From: Colin Sharpe
Sent: 18 December 2012 11:33
To: Jane Tucker
Subject: FW: Consultation on planning application 3/2012/1078 Westholme, Longsight Road, Copster Green

From: Hornby, Mark [mailto:Mark.Hornby@lancashire.gov.uk]
Sent: 18 December 2012 10:48
To: Colin Sharpe
Cc: ENV EPP Customer Service Area East
Subject: FW: Consultation on planning application 3/2012/1078 Westholme, Longsight Road, Copster Green

The proposed garden wall is situated on either side of an existing vehicular access and would improve the sight lines compared to the frontage hedge that was previously there. I therefore have no objection to the proposal, subject to the following condition:

PROPOSED REPLACEMENT GARDEN WALL
and ACCESS GATES at 'WESTHOLME'
LONGSIGHT ROAD · COPSTER GREEN.

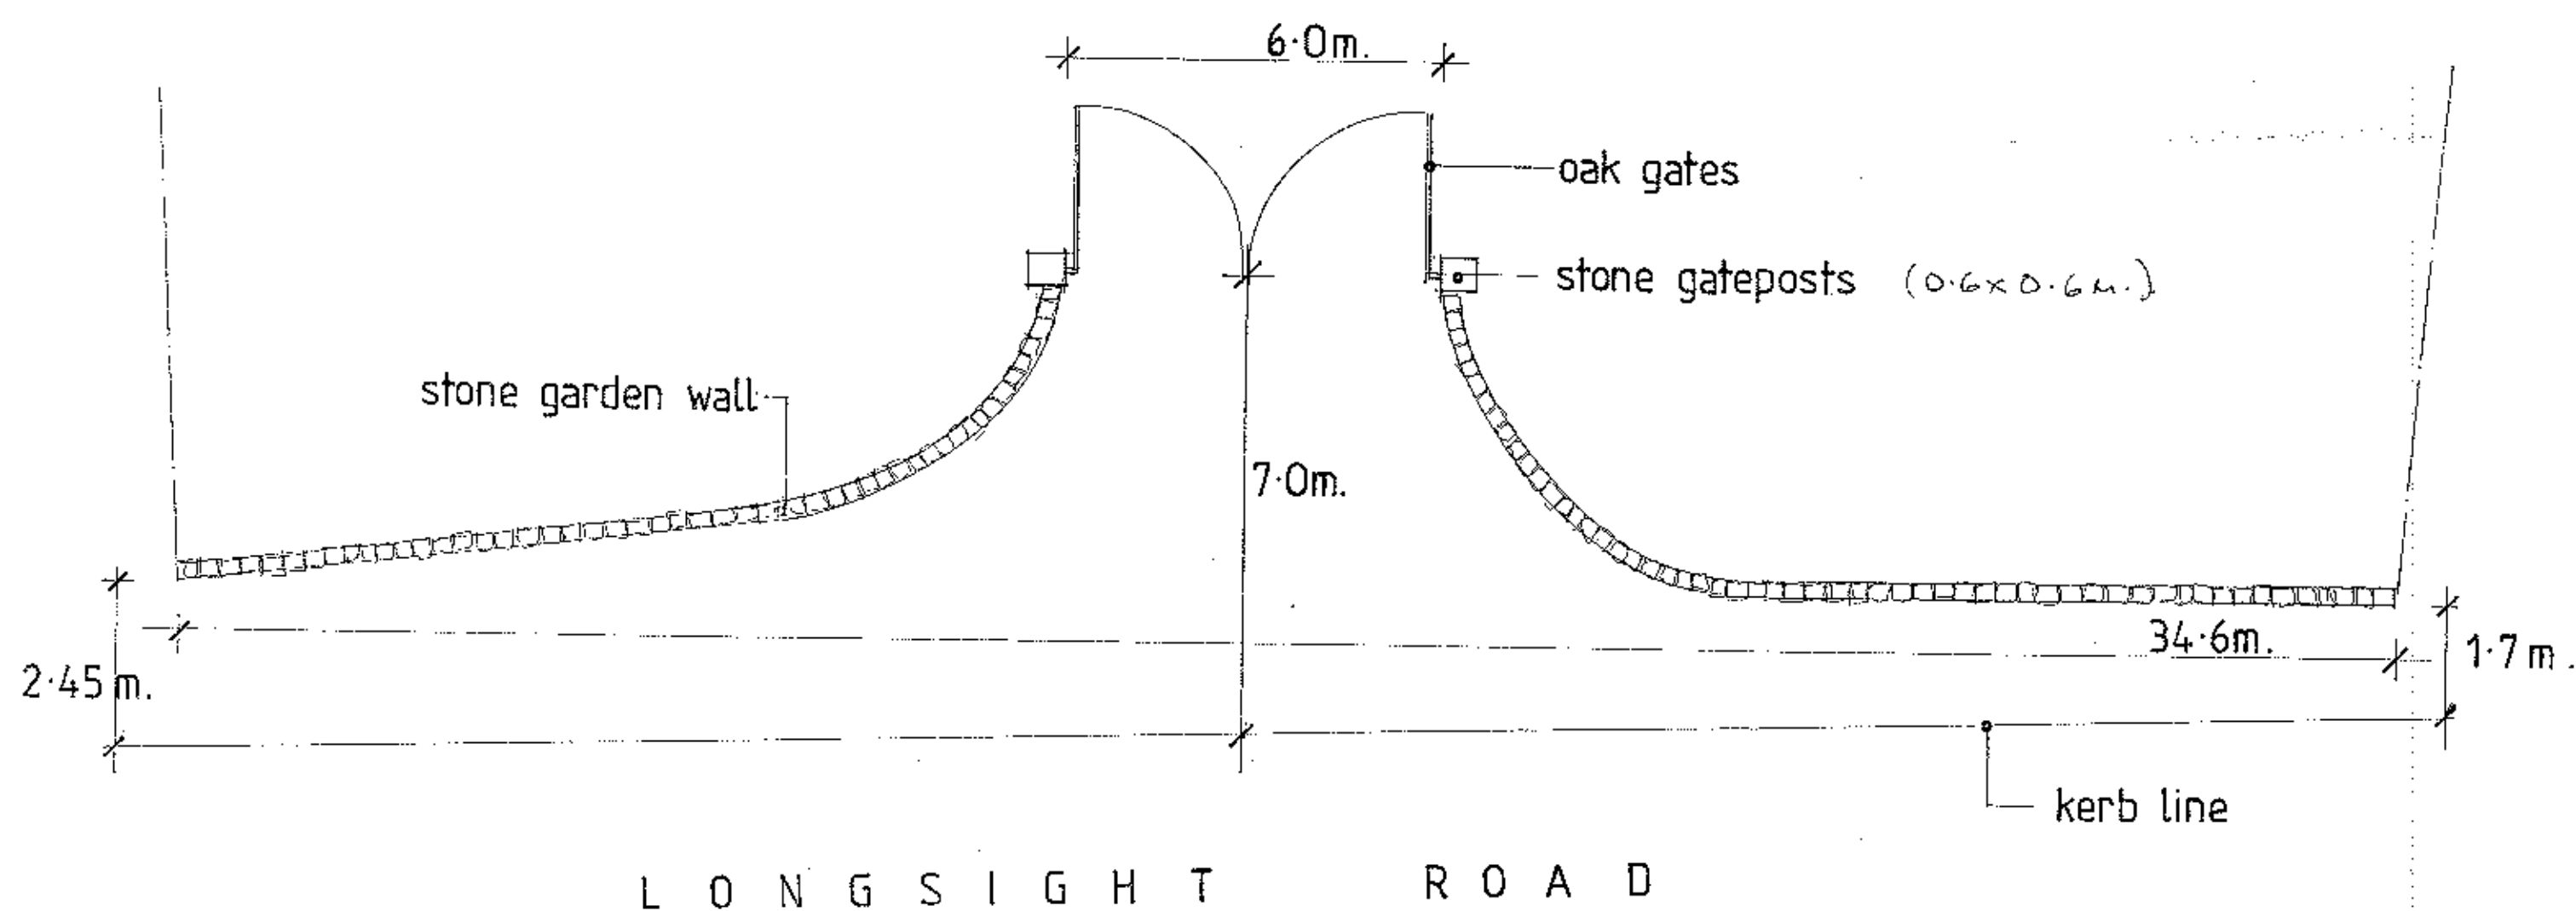
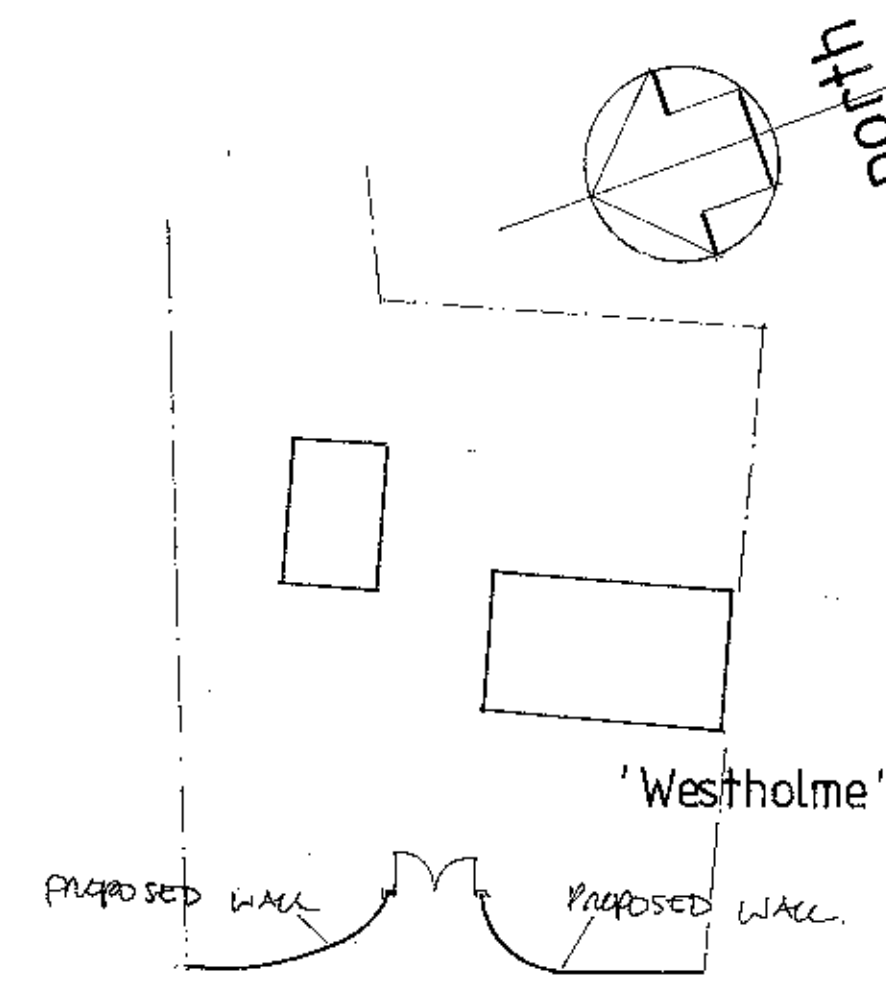
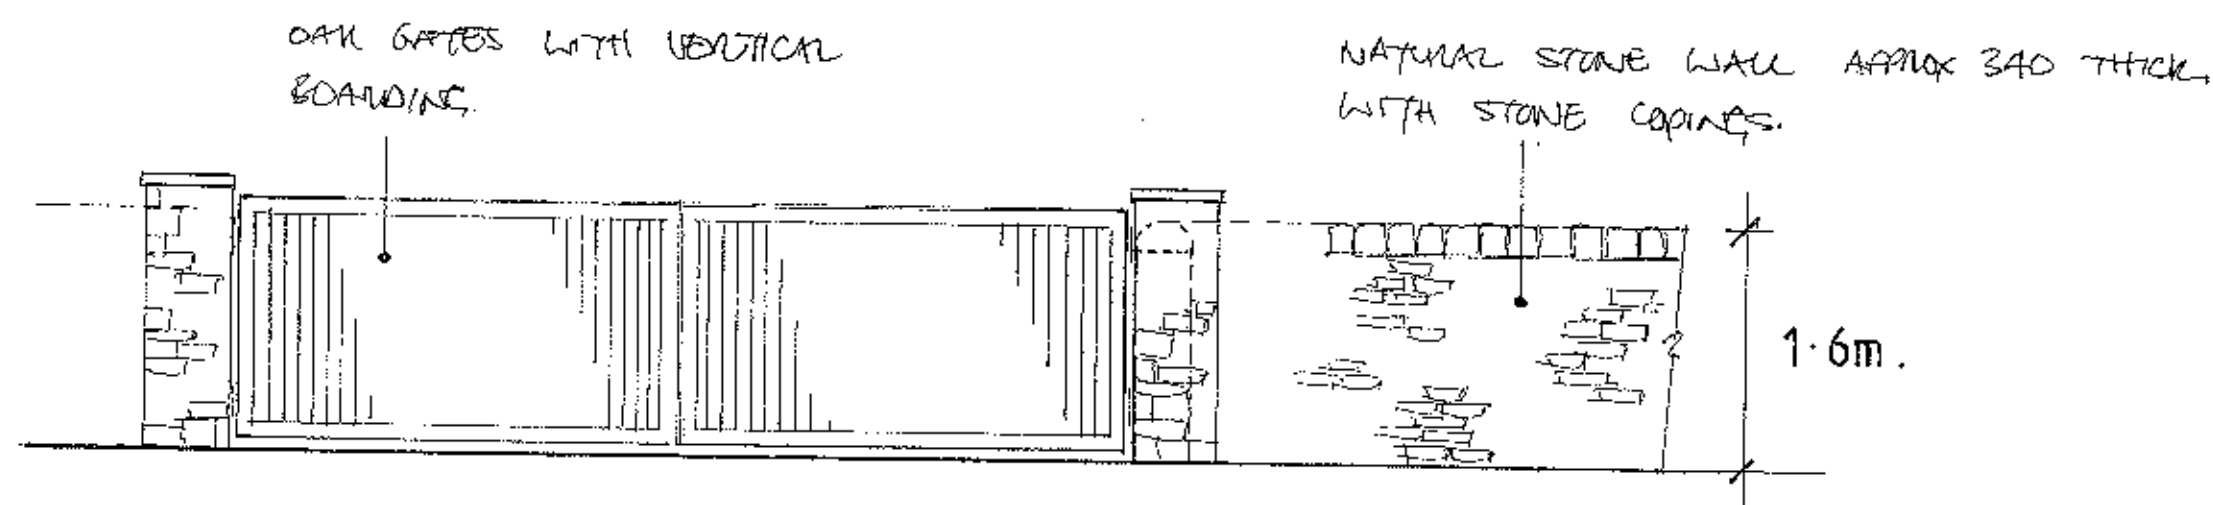
Any gateposts erected at the access shall be positioned a minimum of 5 metres behind the nearside edge of the carriageway of Longsight Road. The gates shall open away from the highway. Reason: To permit vehicles to pull clear of the carriageway when entering the site.
